**Application by Fosse Green Energy Ltd for an order granting development consent  
for the Fosse Green Energy solar farm**

**Deadline 3 –  
Response to Examining Authority’s  
Second Written Question TT.2.03**

**NKDC reference: 23/0325/NSIP**

## Status of “Stepping Out Routes”

Figure 3-3

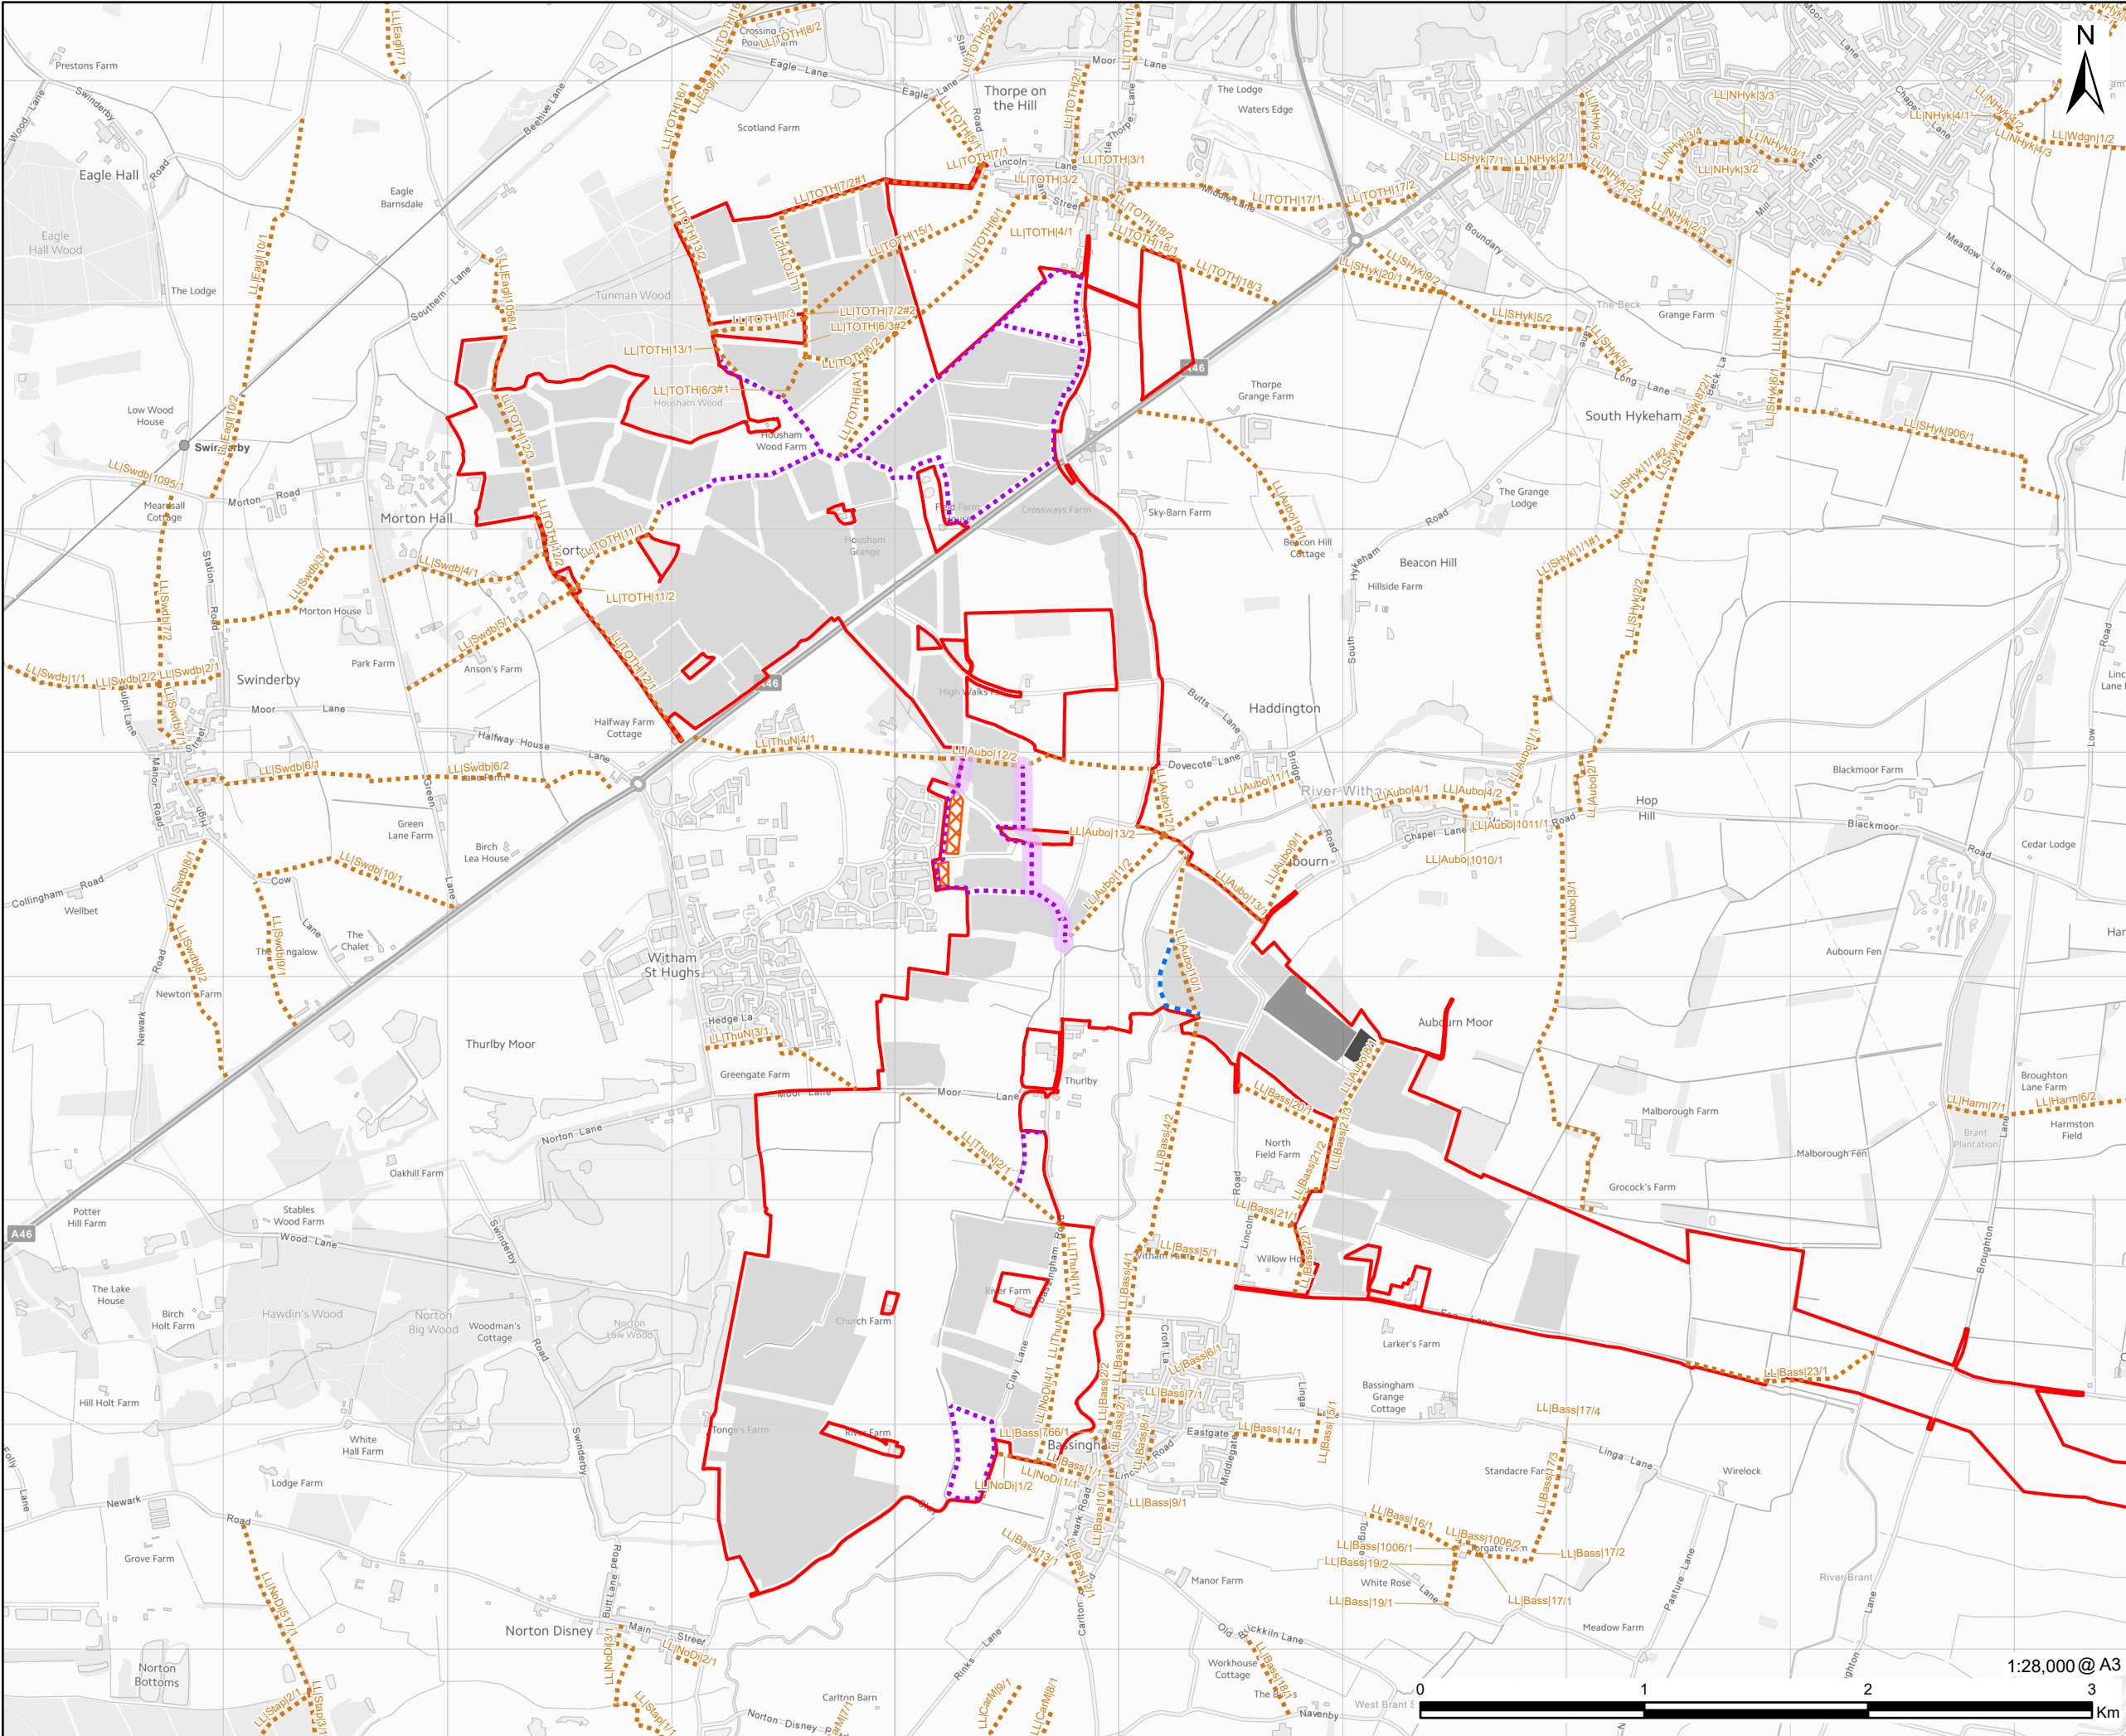
9. This statement is repeated, for instance on pages 139 and 140 of REP-030. However, the only permissive paths shown AS-024 as ‘Retained Permissive Paths’ (as distinct from ‘Proposed Permissive Paths’ in the key) are some lengths of path immediately east of Witham St Hughs. It is not possible to tell which identifier (see paragraph 6 above) relates to which of those Retained Permissive Paths; and it is difficult to see how those amount to seven retained paths. AS-024 does not show those parts of the Stepping Out Walks which follow permissive paths

20. Drawing AS-024 does not show any of the permissive paths currently used by the Stepping Out Walks Thorpe on the Hill or Morton and Tunman Wood. This includes the following sections shown on the plan appended to this response:

- C-D, F-G-H-I and J-K which are neither shown as Proposed Permissive Paths nor as Retained Permissive Paths.
  - D-E-F – which are shown as Proposed Permissive Paths on AS-024, and which the Applicant has shown as “new permissive path” on the Streets, Rights of Way and Access Plans REP2-004

21. In addition, there is a short length of path X-F which is shown as a Proposed Permissive Path on AS-024, but is in fact a length of statutory PRoW TOTH/13/1 which the Applicant proposes to permanently divert.

24. Some of the “new permissive paths” appear in fact to be existing permissive paths – section D-E-F is approximately 300m in length. Additionally, existing sections of permissive path C-D, F-G-H-I and J-K totalling approximately 1.8m in length would be lost. Whilst new lengths of permissive path would be created, this means that the net length of permissive path provided for would be some 2.1km shorter than indicated by the Applicant.

25. Furthermore, it is suggested that a check should be made of the 9.5km length of permissive path which the Applicant has stated that it will provide as part of the Proposed Development. The initial scaling of the routes shown on AS-024 indicates that the length of Proposed Permissive Path may be approximately 8km, significantly shorter than that claimed, even if it were accepted that these are as new (i.e. not retained) permissive paths – something which the Council currently does not think is the case.

27. Therefore, following the discussion at ISH3, the Council suggests that it should work with the Applicant to:
  1. identify existing permissive paths on a plan

2. carry out a check of what is shown on the relevant plans as “New permissive paths”, and identify:
    - a) the retention of existing permissive path lengths

- b) those existing permissive paths to be lost
  3. clarify those permissive paths which are to be new, additional permissive paths
  4. quantify the net benefit of the Proposed Development in terms of permissive path lengths
